Y/71/21/OUT – Land At Little Meadow And East Of Bilsham Road
Yapton - Local Highway Authority (LHA) Comments on Transport
Issues, as addressed by Transport Addendum from Nick Culhane
Highway Consultant

Junction Arrangements

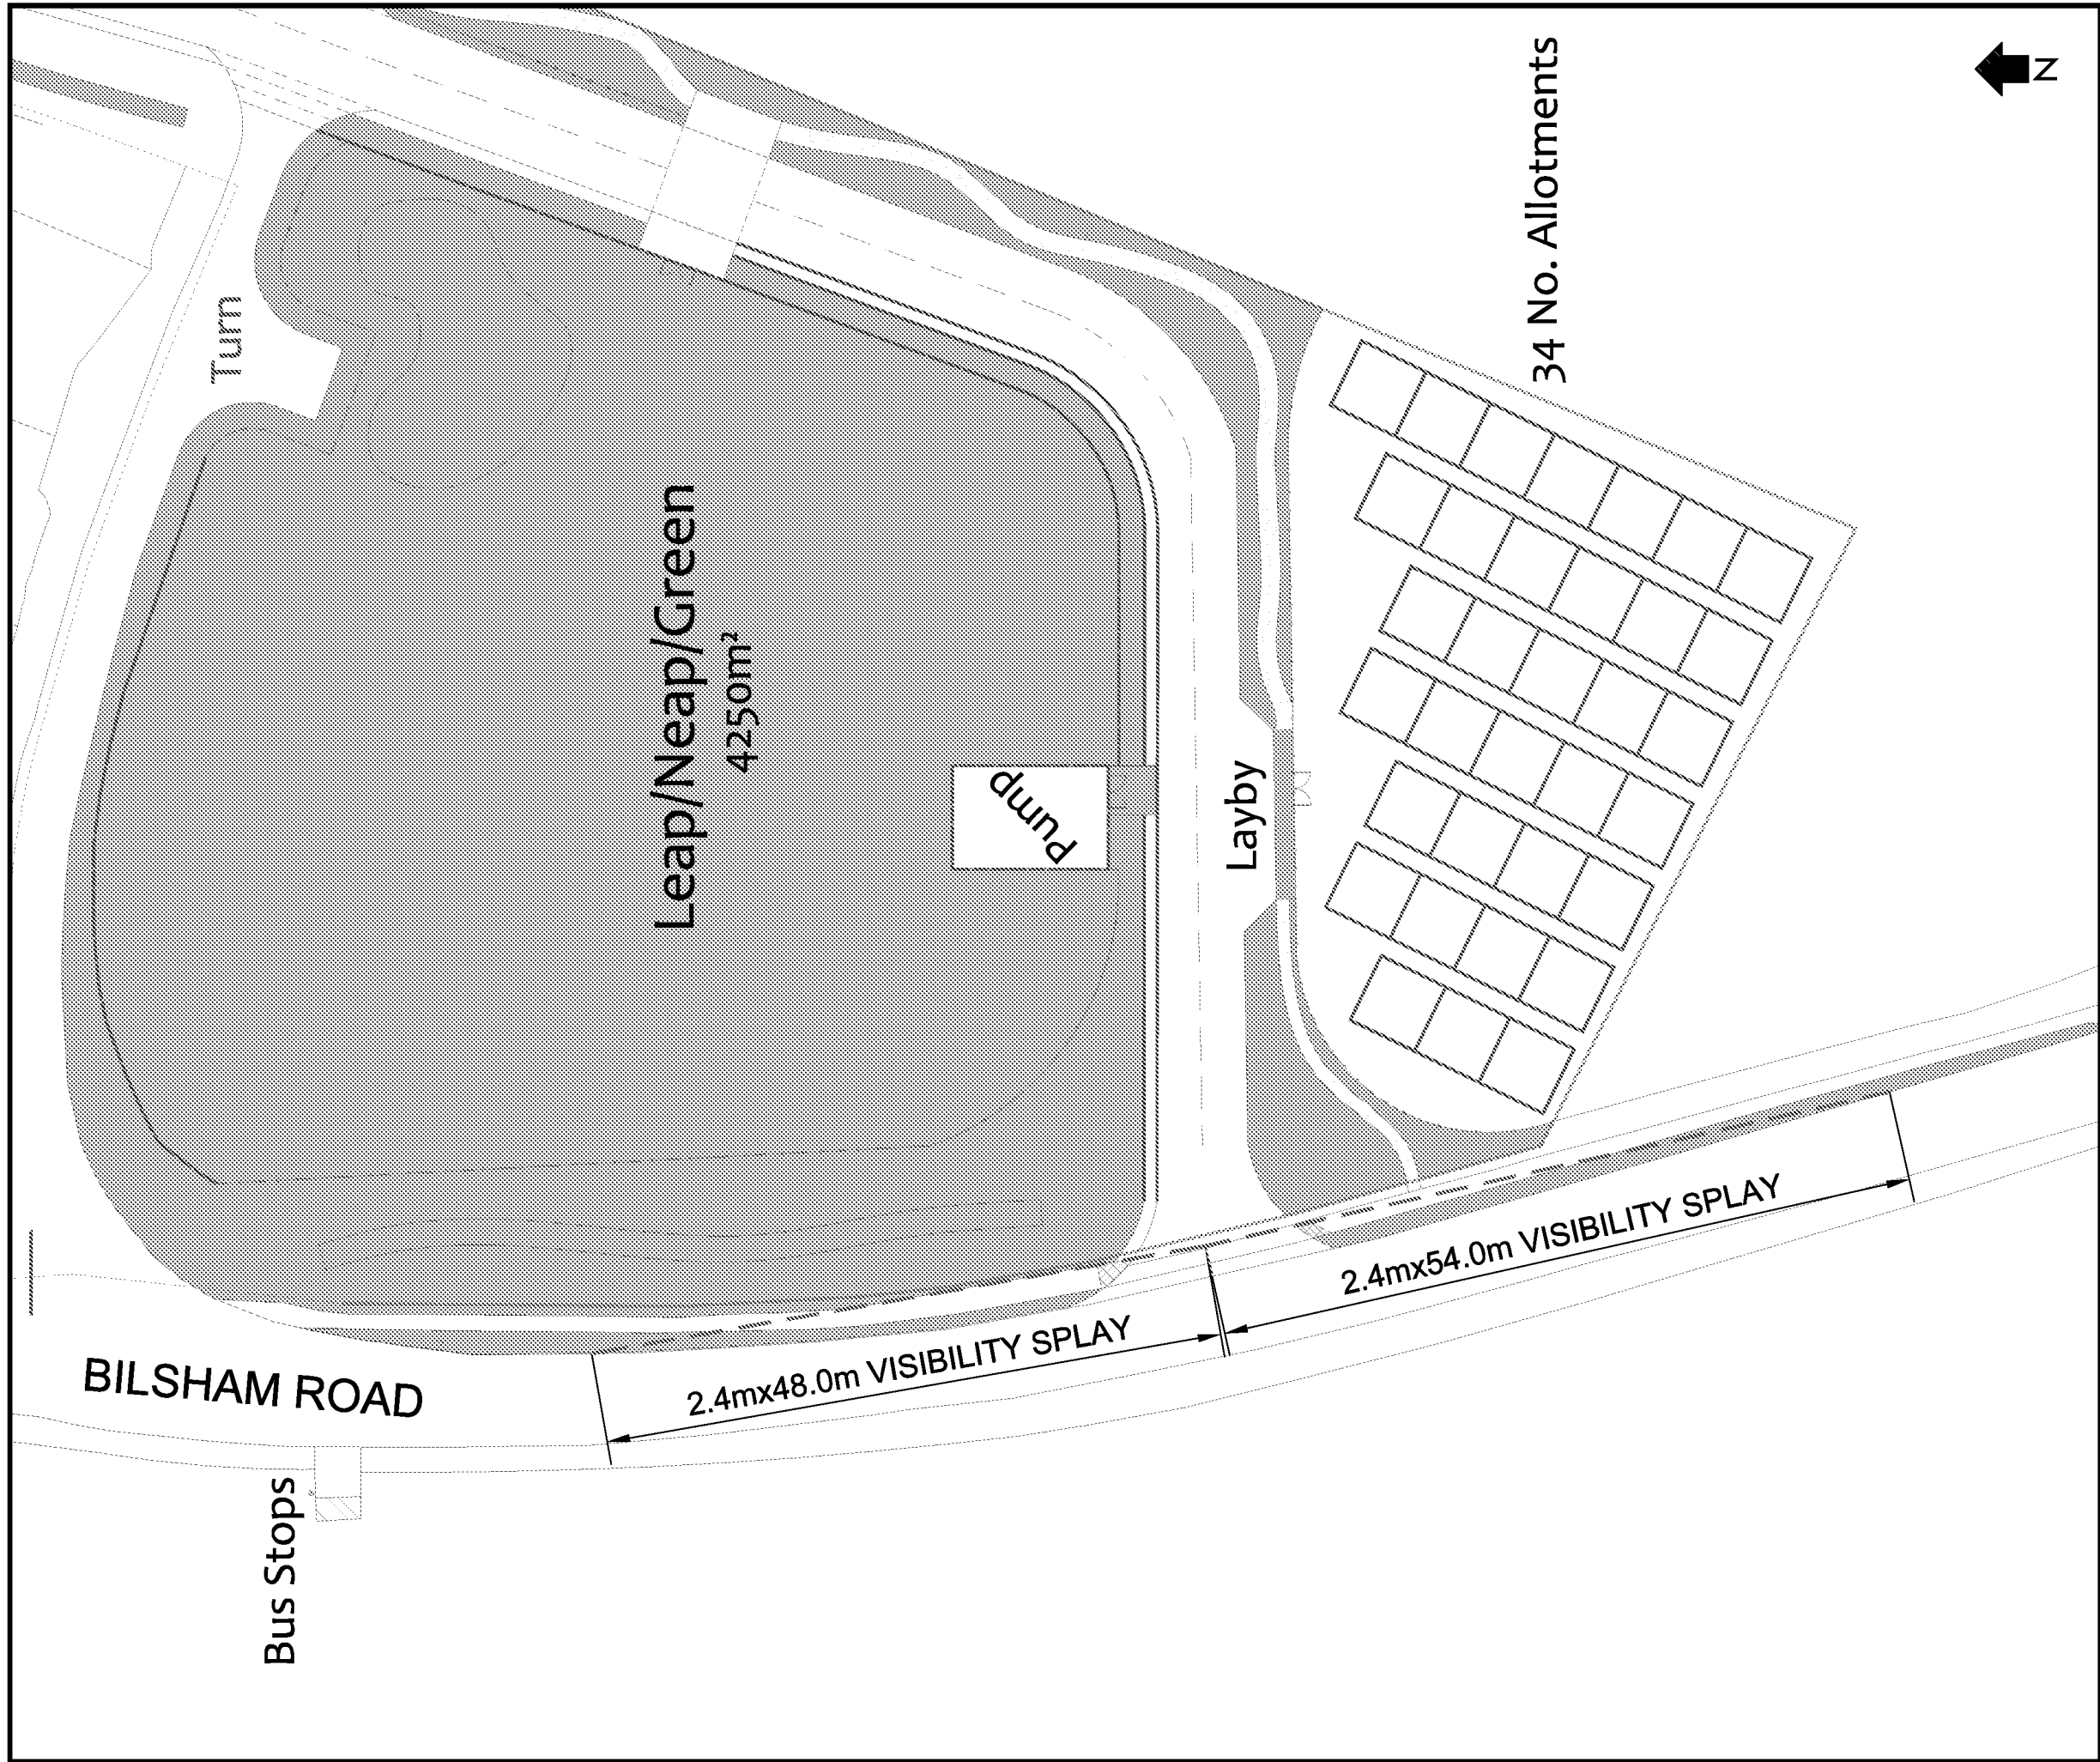
Demonstrate clearer access and site plan, show proposed localised footway widening, footway tie in to site and existing and dropped kerb tactile paving pedestrian crossing point of the new junction and of Bilsham Road to the west side bus stop.

Explore option of closing off/stopping up GLW junction and demonstrate turning area for the existing dwellings is workable from the new access road direction.

Clarify Little Meadow access arrangements, whether the industrial estate/ new development can be accessed this way – if so, demonstrate suitable visibility at the existing access point to Bilsham Road.

This has been shown in greater detail on drawing NJC-002 'Footway Improvements' and includes localised widening of footway, tie-in and dropped kerb tactile paved crossing point of the new junction. Dropped kerb and tactile paving is also shown on the southern side of GLW and on Bilsham Road opposite the bus shelter. Opposing crossing points have not been shown because the opposite sides of carriageway are verged with no hardstanding footway. The dropped kerb across GLW should not feature tactile paving to avoid confusion for visually impaired. Bus stop improvements should include hardstanding and kerb with corresponding dropped kerb and paved tactile to improve safe crossing and waiting for pedestrians. Furthermore, the Local Planning Authority (LPA) should take a view on the isolated location of site. The nearest amenities are in Yapton to the north yet there is no continuous linking pedestrian infrastructure on this route.

GLW junction with Bilsham Road will not be stopped up so that access to existing dwellings can be maintained. No additional dwellings or use will be served. To ensure no through traffic to the new access road, bollards or similar treatment should be provided. Traffic Regulation Order would be required for prohibiting through traffic from GLW to the new access road and this would be secured through s106 agreement. A turning area is shown on the existing GLW serving the existing dwellings but tracking for servicing vehicles has not been demonstrated.

The Addendum mentions that access through GLW to Bilsham Road for the industrial units is not possible however this does not clarify whether the existing Little Meadow access from Bilsham Road, to the north, will therefore be used. Visibility for this junction has not been demonstrated and appears restricted by the road layout in this location. Ideally the access routes to and from the increased industrial use should be provided with swept path tracking and demonstration of suitable visibility on to the public highway, which could be supported by a speed survey at extent of achievable splays from Little Meadow access. If the industrial development is to be accessed from the new access road route only then this should be demonstrated through tracking and arrangements for closing existing route to Little Meadow provided.
